From: [REDACTED]
To: [Hinckley SRFI](#)
Subject: HNRFI latest submission from Tritax
Date: 07 February 2025 14:44:34

Interested party ref 20038973

I would like to make the following comments regarding the above:

**SAPCOTE ENHANCED
SCHEME
VISIBILITY TO
PEDESTRIAN CROSSINGS**

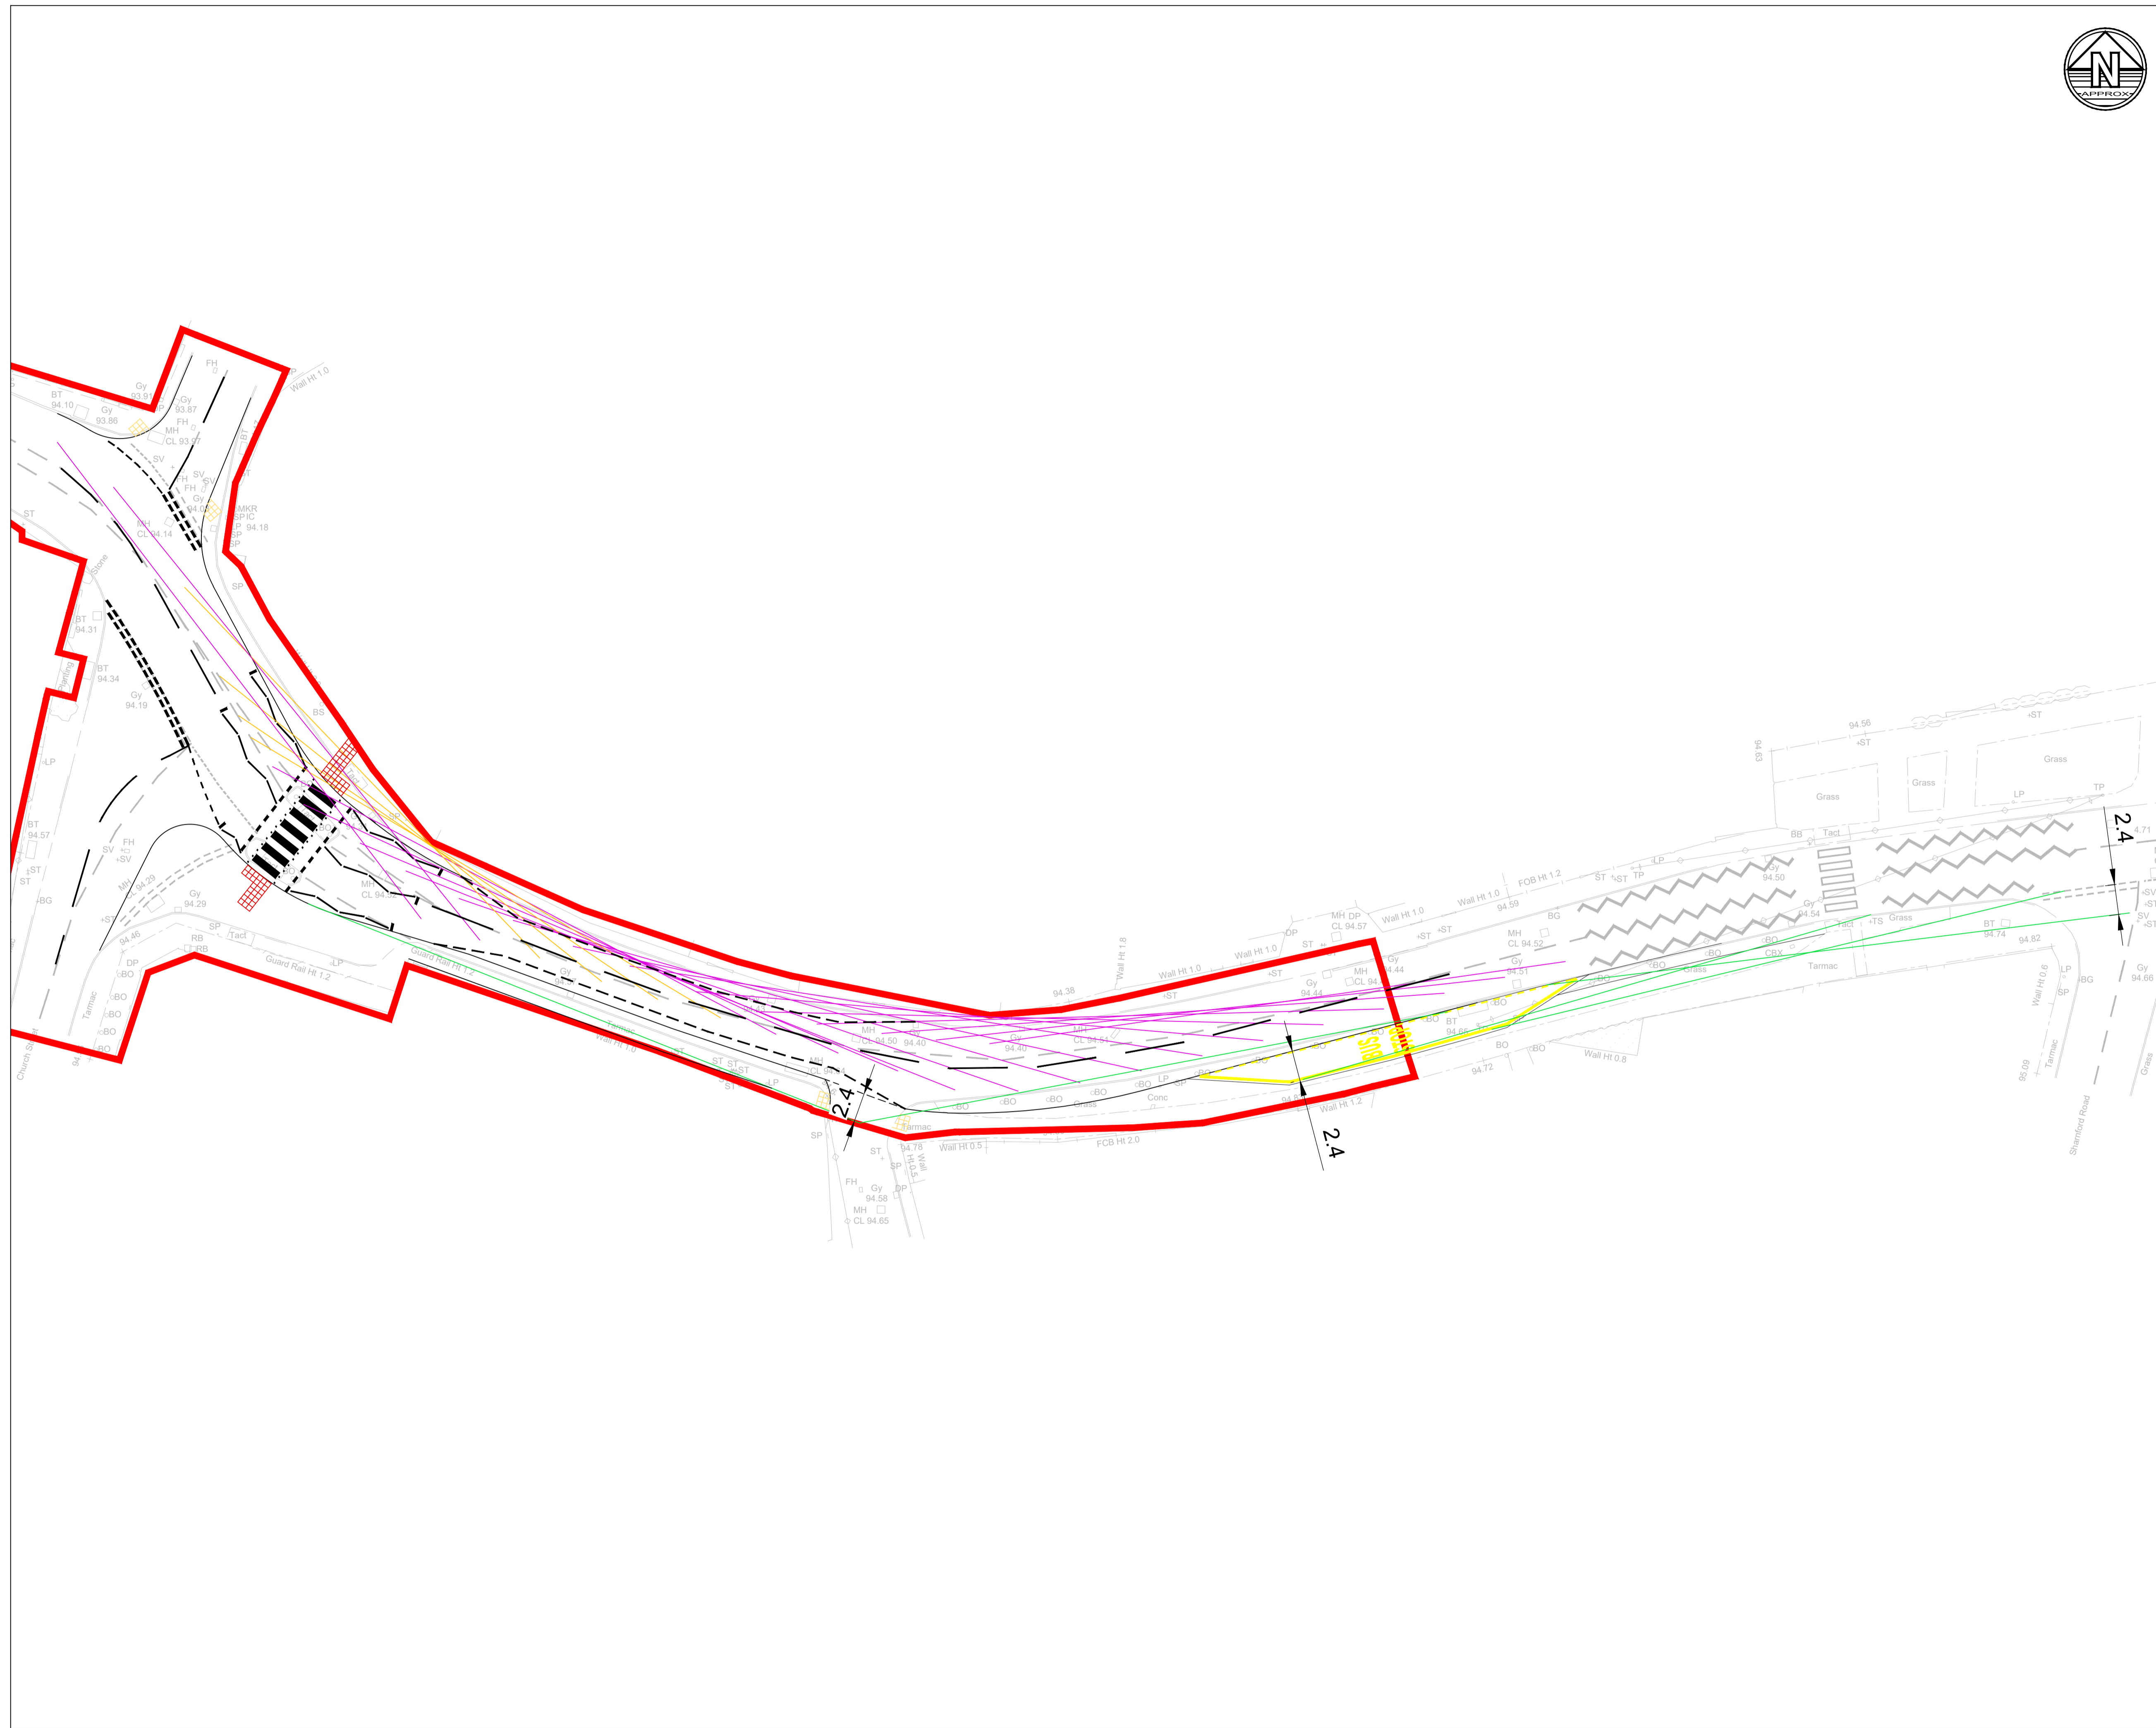
The proposal to remove the central refuge from the crossing area will create two hazards, firstly the view of oncoming traffic for pedestrians will be limited and secondly the central refuge currently acts as a deterrent against vehicles speeding when approaching the crossing and the crossroads.

**Sapcote Enhanced Scheme
Appendix C (part 6)
Vehicle Tracking Sheet 2**

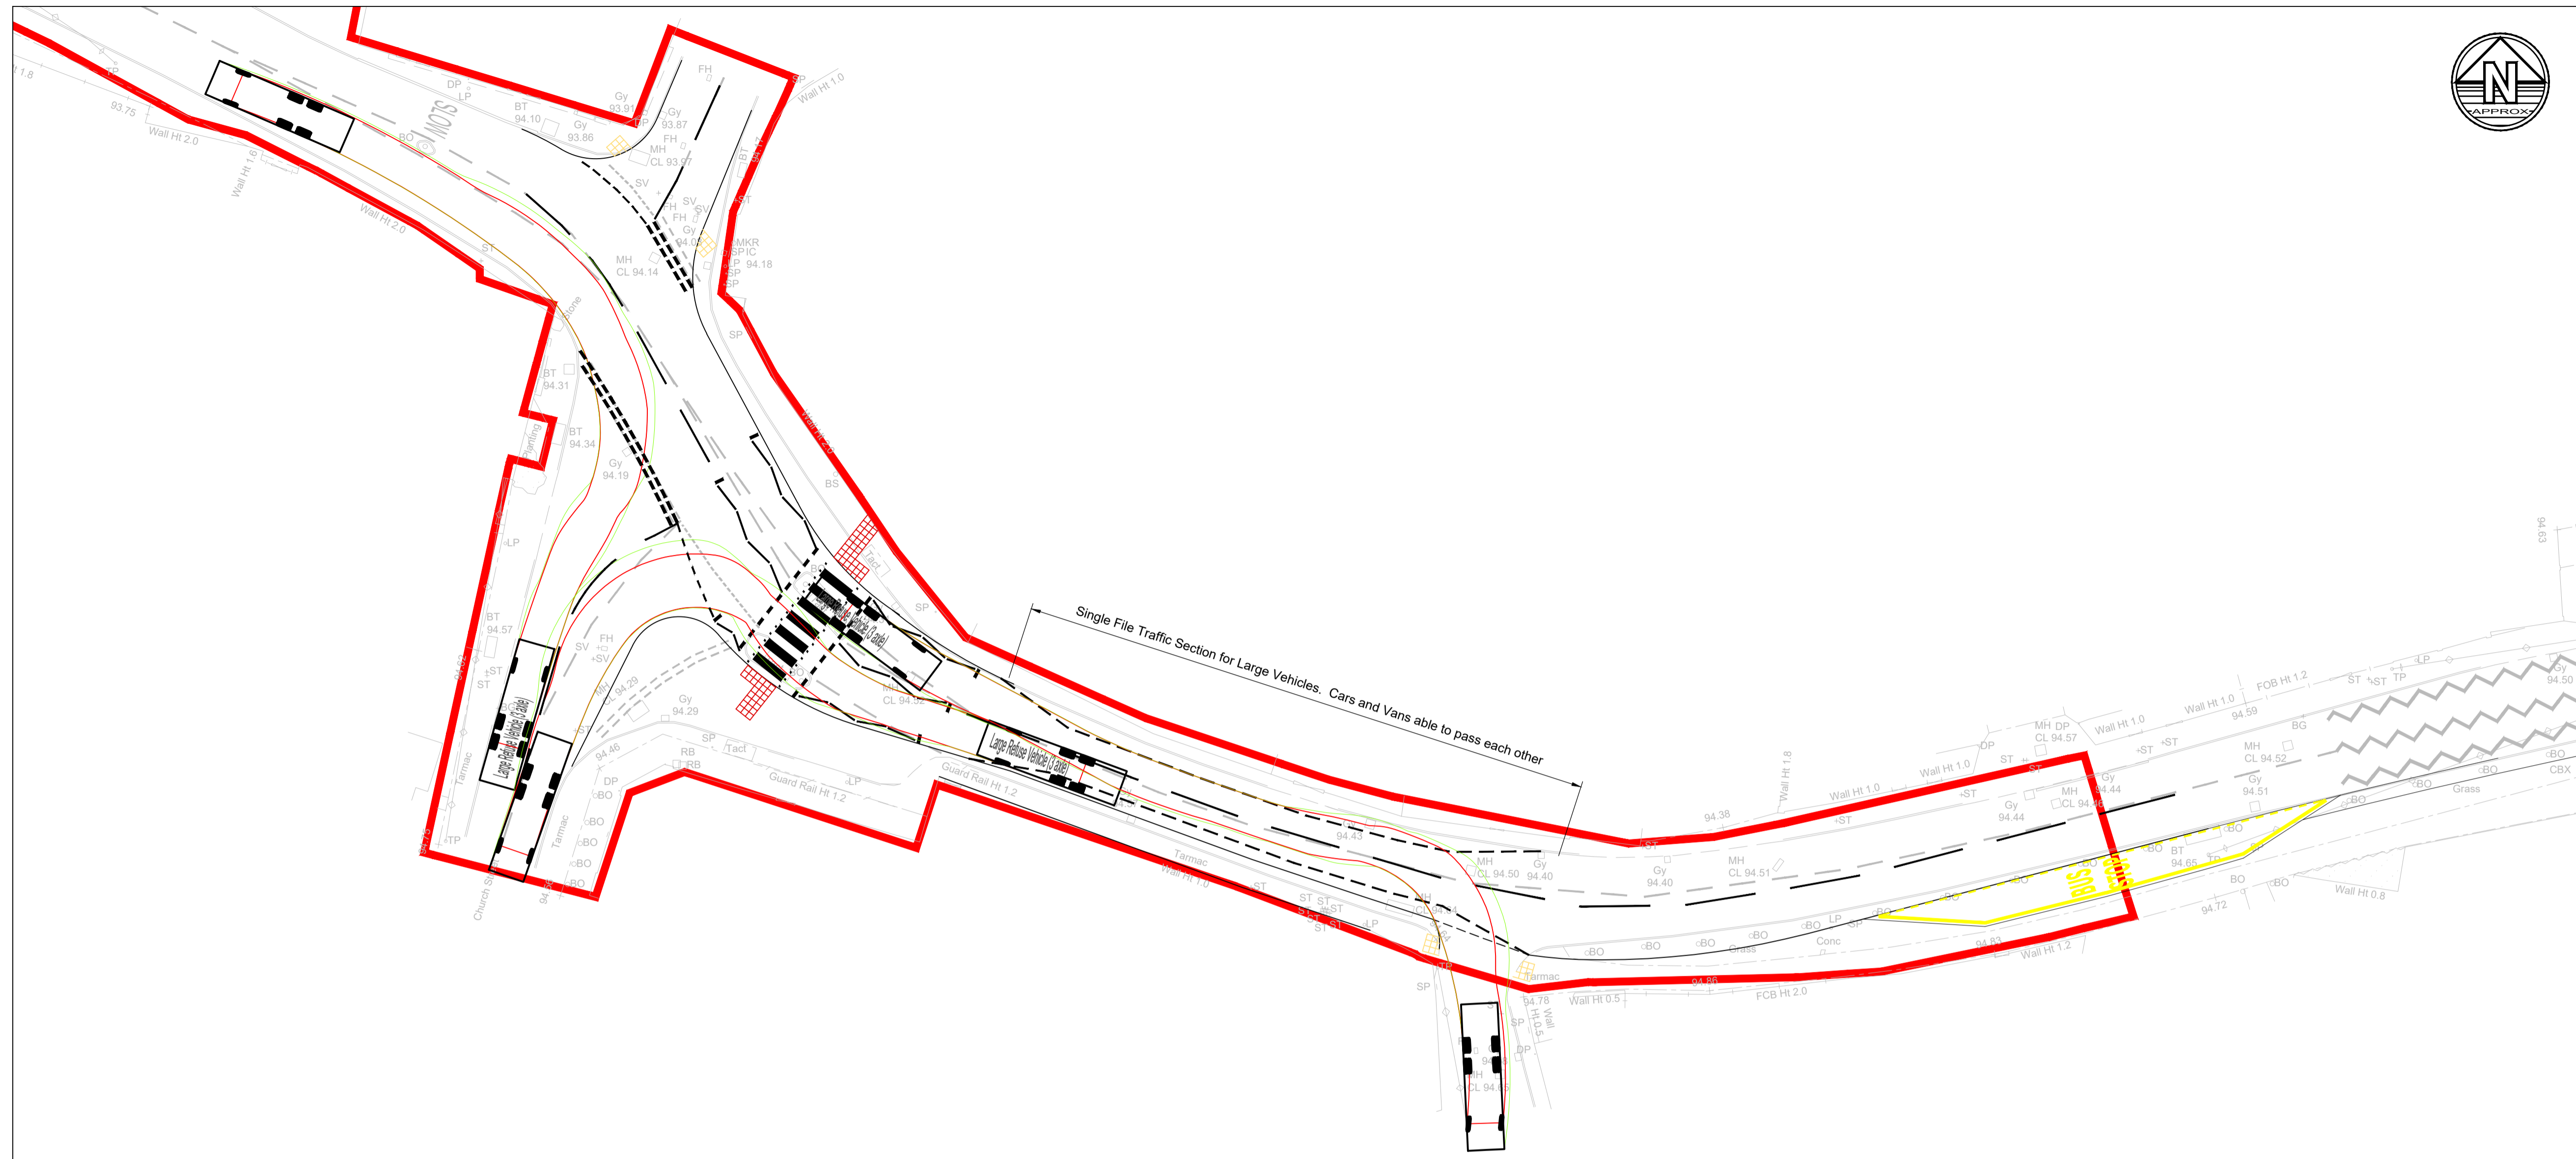
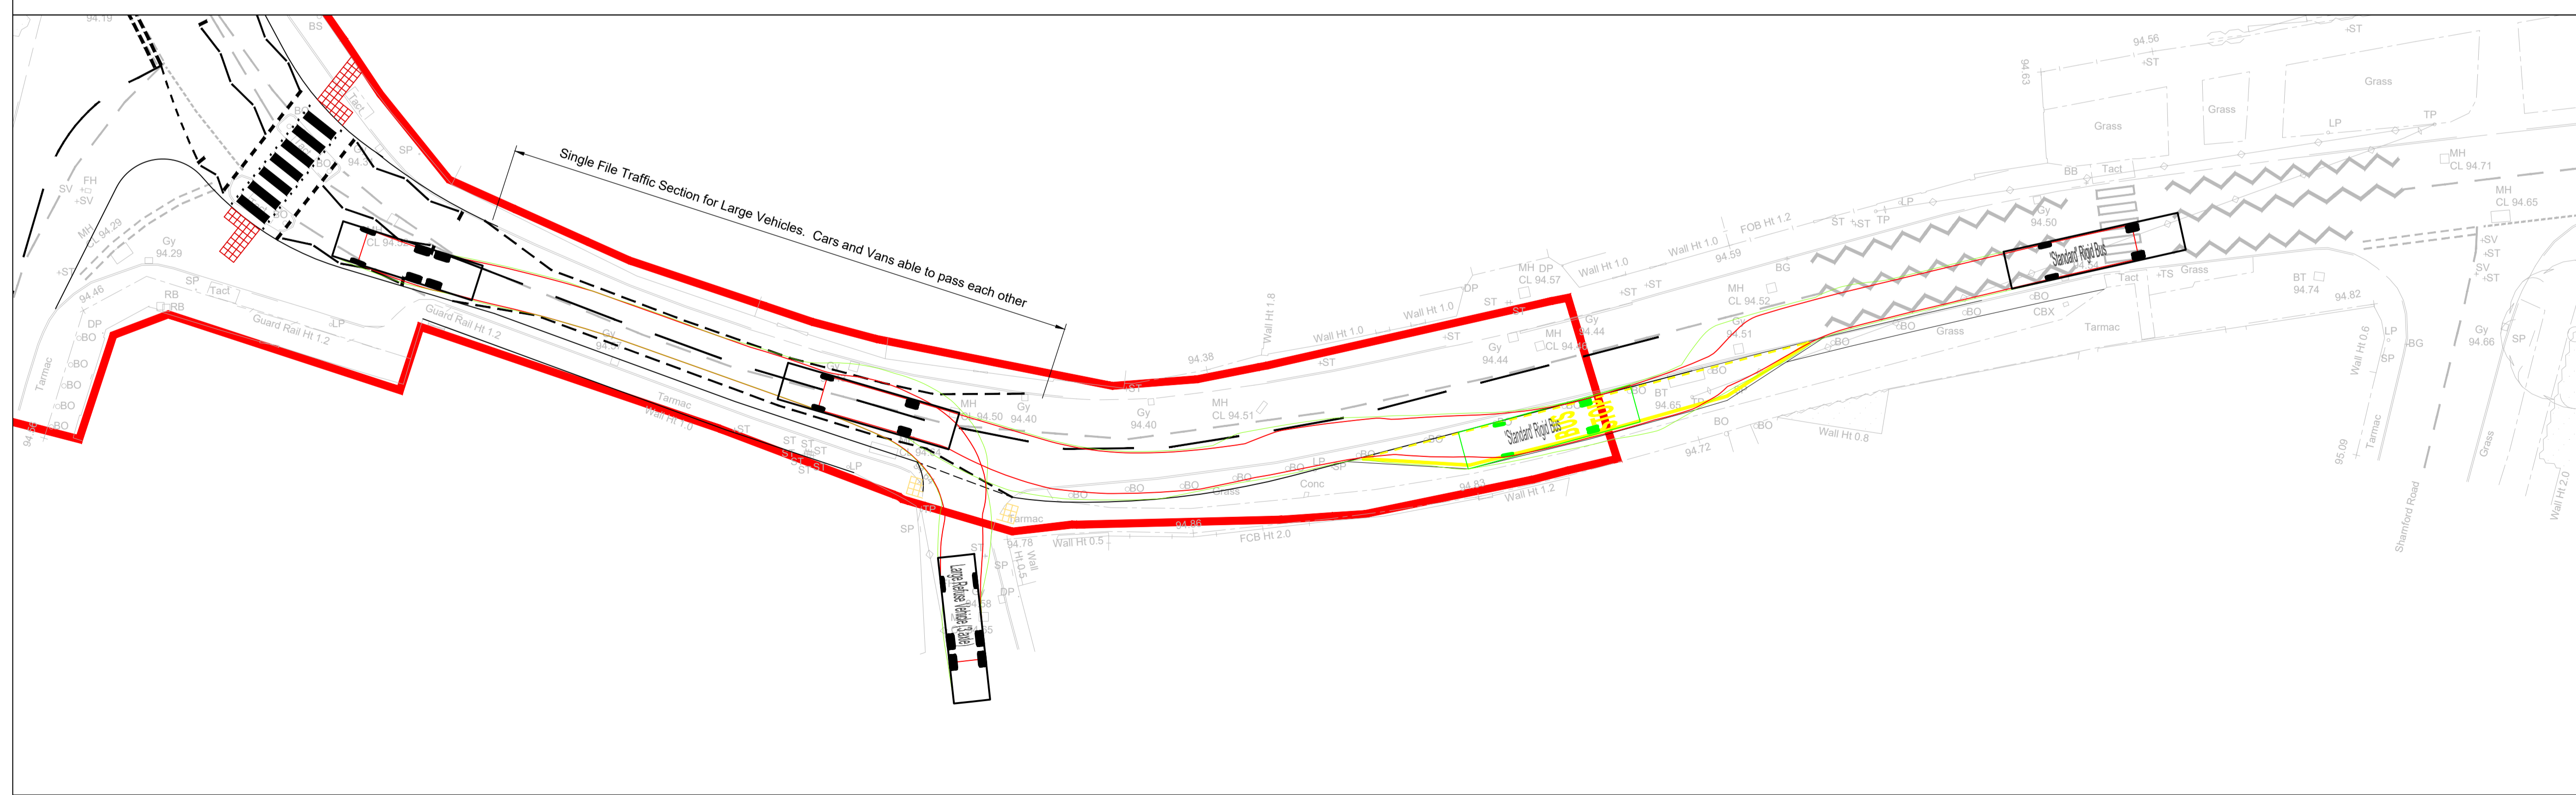
Whilst the proposals are intended to improve things it is interesting to note that the Vehicle Tracking Sheet 2 would appear to show that two lorries have actually hit each other in Church Street. I also envisage problems with delivery lorries turning into Church Street from Hinckley Road when there are vehicles wishing to exit Church Street.
